Case Officer: Hansah Iqbal

Recommendation: Refuse

Proposal: Single storey porch and two storey extension to side and rear of existing dwelling

Elevations - Outbuilding (to be demolished)  
as existing - 1:100

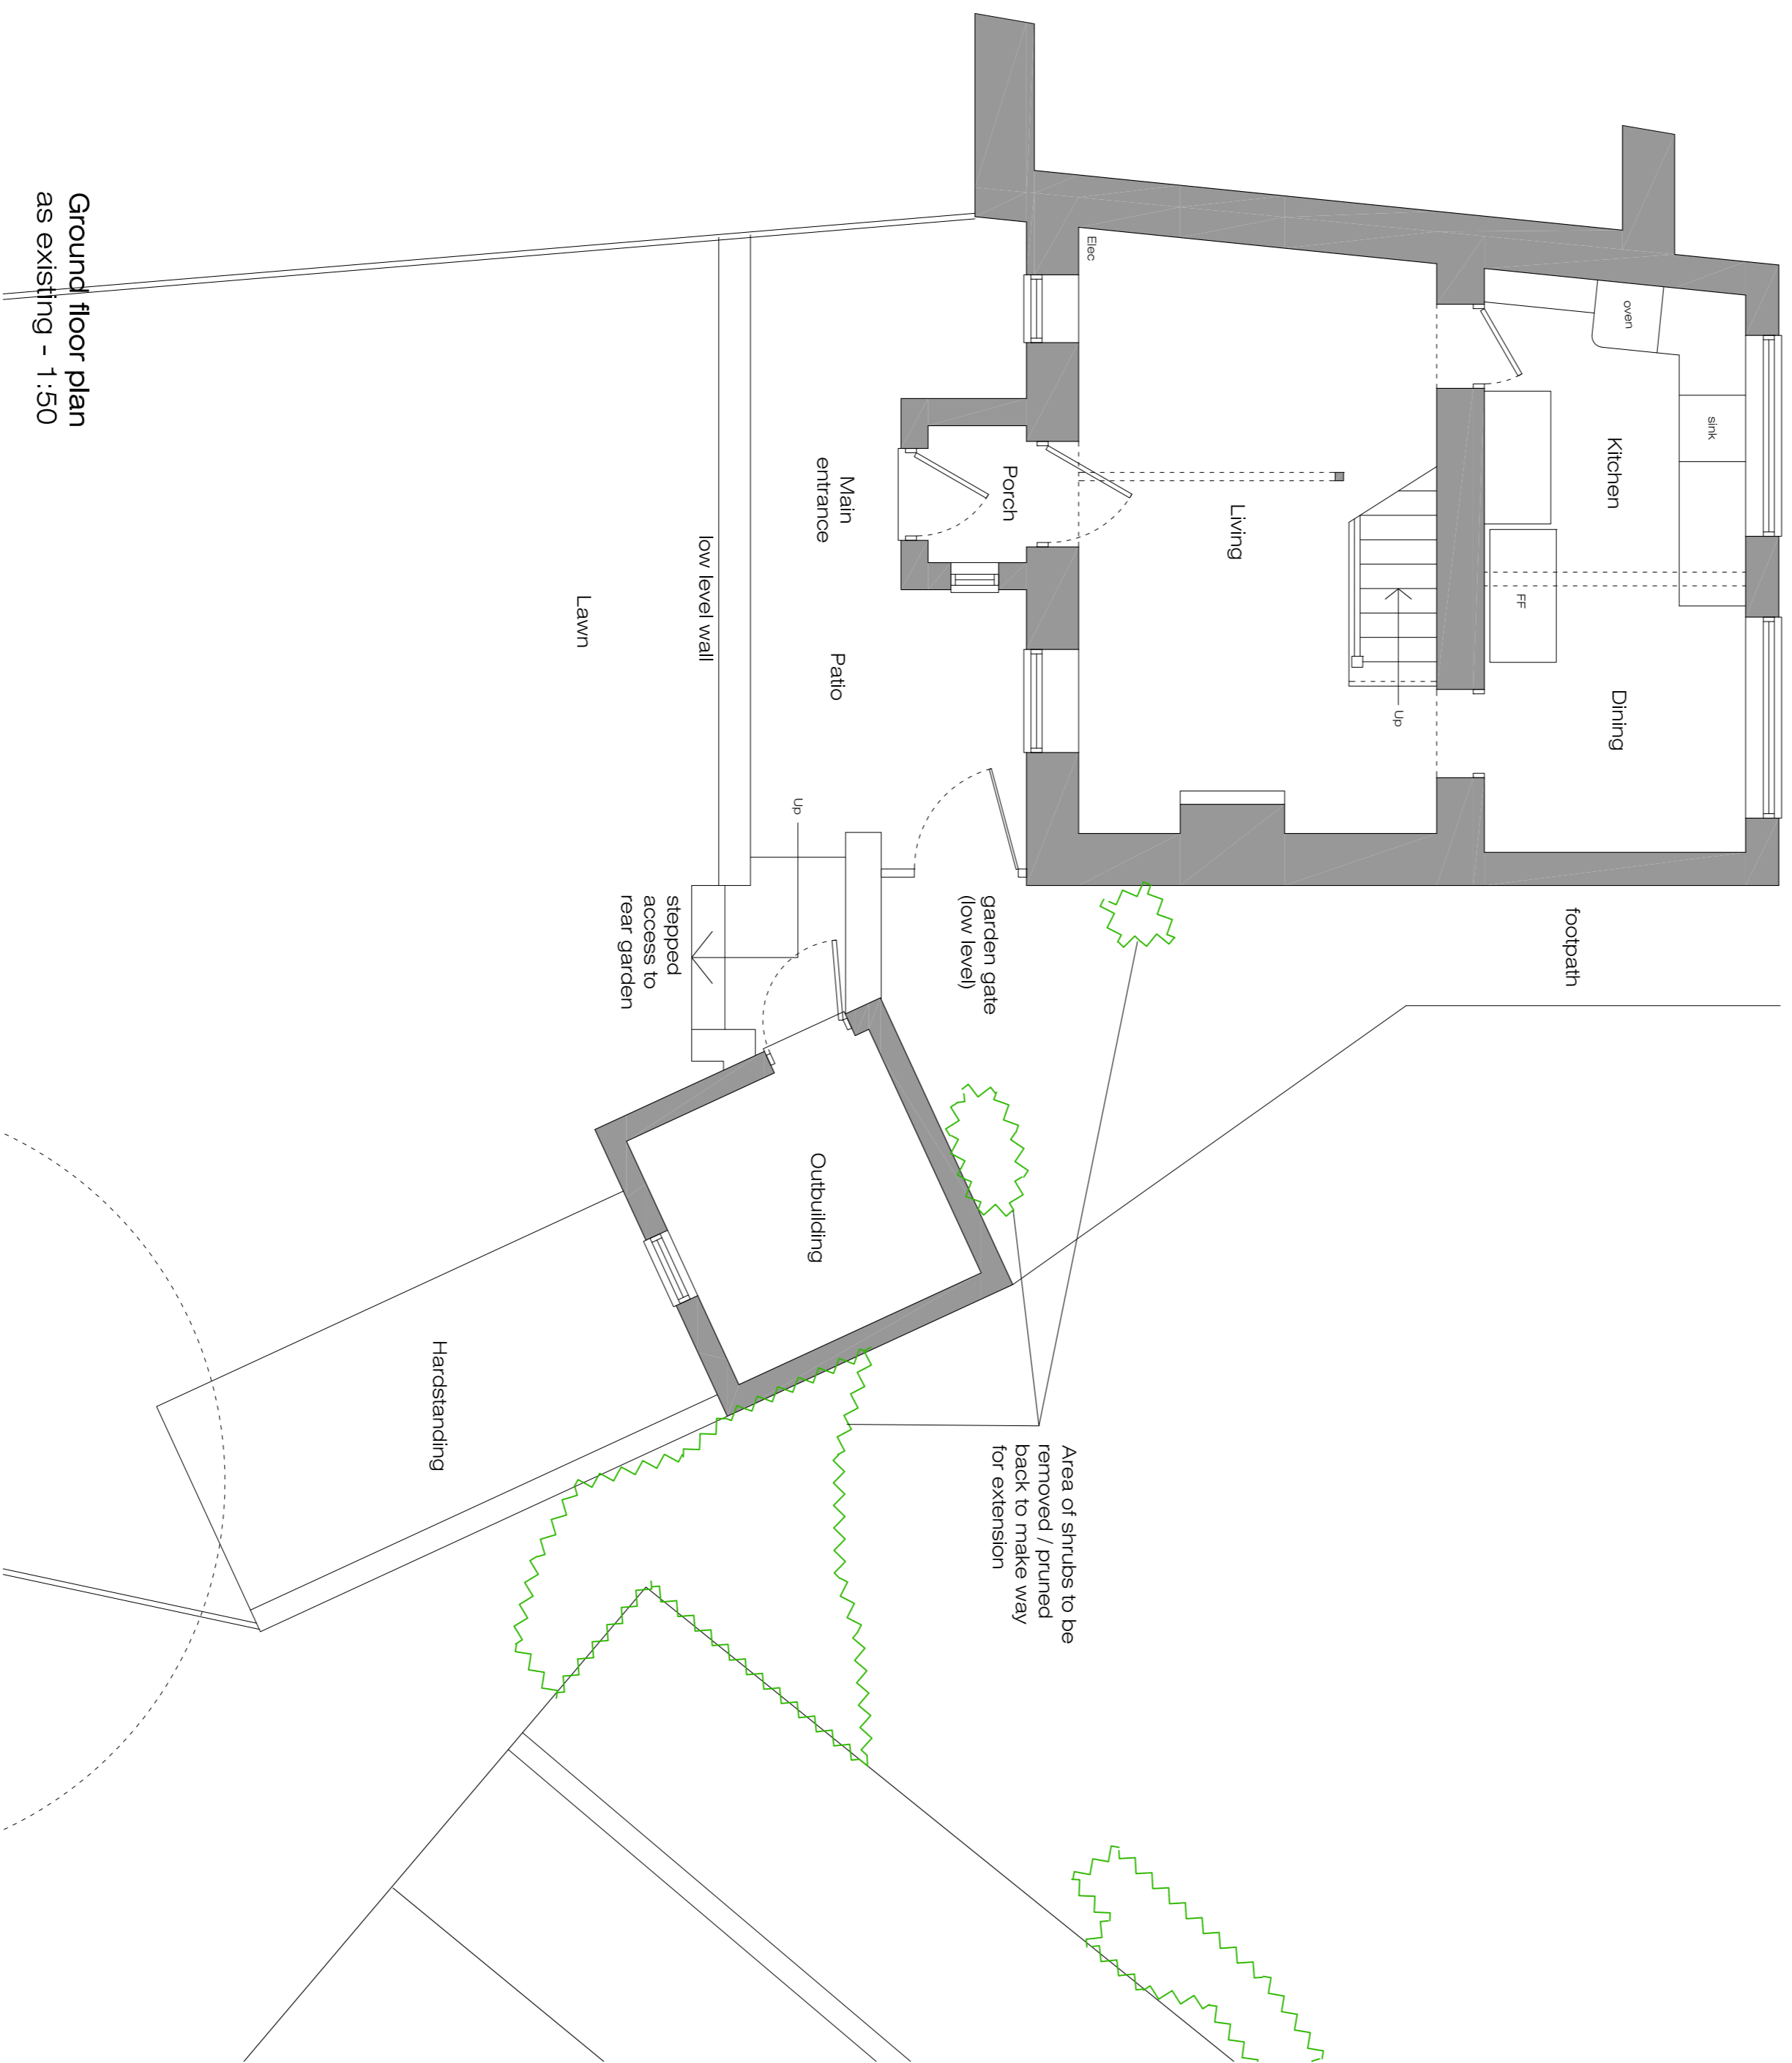
The proposed development would involve the replacement of an existing single storey stone outbuilding with a two storey extension off the north-eastern elevation of the existing dwelling, running along the north-eastern boundary of the site for a distance of 8 metres at two storey height. The proposed extension would result in a substantial increase to the footprint of existing dwelling, approximately 5m² short of doubling the size.
